Recommendation Report for Planning Permission for Works or Extension to a Dwelling

REF NO: FP/65/22/HH

LOCATION: 54 Flansham Lane
Felpham
PO22 6AH

PROPOSAL: Erection of single storey side/rear extension to create self-contained annexe for ancillary use.

GROUND FLOOR PLAN PROPOSED 1:50

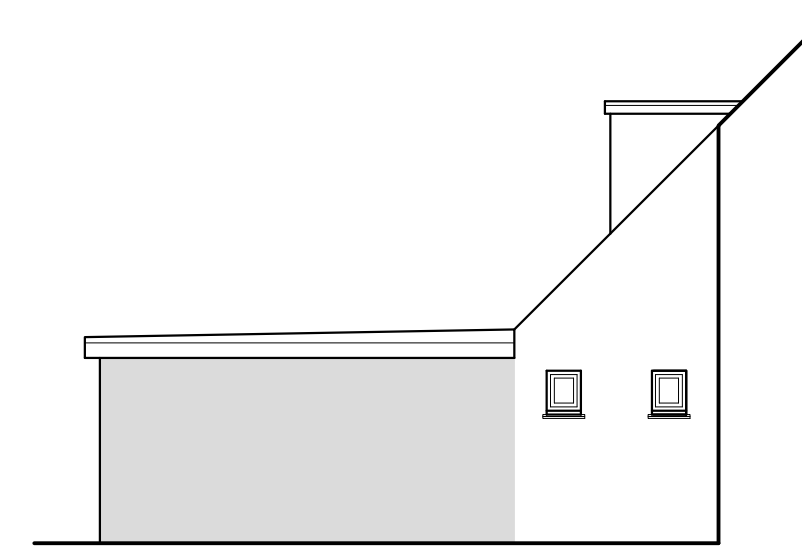
The extension will have a depth of 5.2m and a width of 6.1m. This will not result in adverse overbearing or overshadowing retaining 2.2m to the northern boundary and 0.8m to the southern boundary.

The extension is self-contained but is ancillary to the main dwelling. It does have its own access door although with the development attached to the main building, additional noise and disturbance will not be significant with it similar to that of the main house.

EAST ELEVATION PROPOSED 1:100

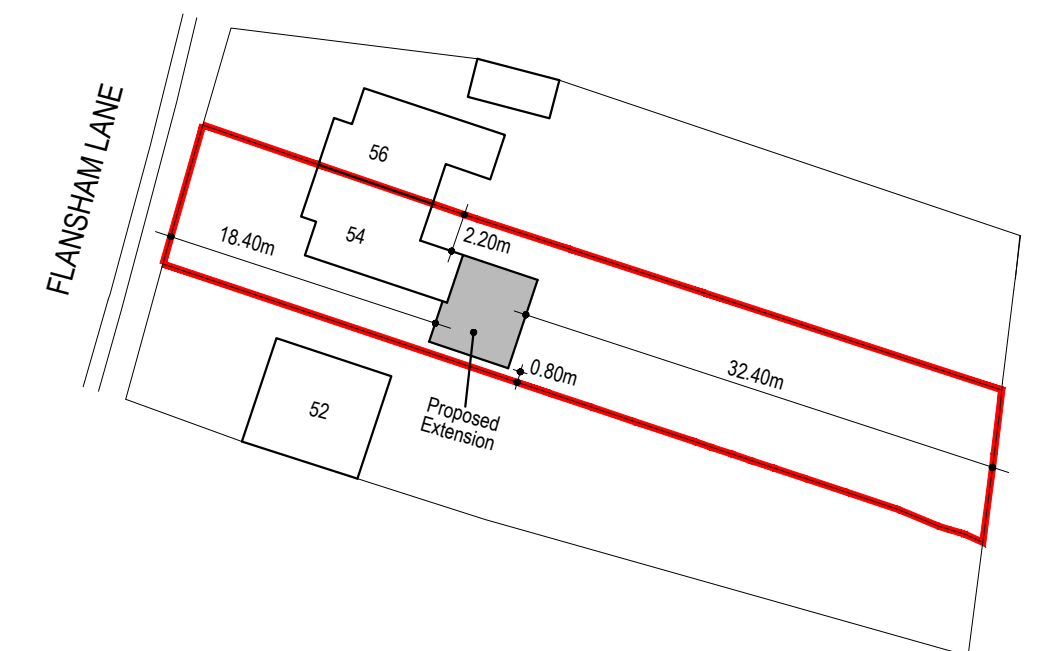
The extension is to the rear however as it extends beyond the side elevation of the dwelling, it will be visible from the scene although it will be set back 18m from the highway and appears subservient to the host dwelling.

The property has a cat slide roof to the rear and the extension will meet in line with the eaves ensuring it appears well integrated and appropriate in scale. Materials consist of rendered masonry to match the host dwelling.

There are no side windows proposed but there will be a window and door to the rear elevation. At single storey, this will overlook the rear garden and does not result in adverse overlooking.
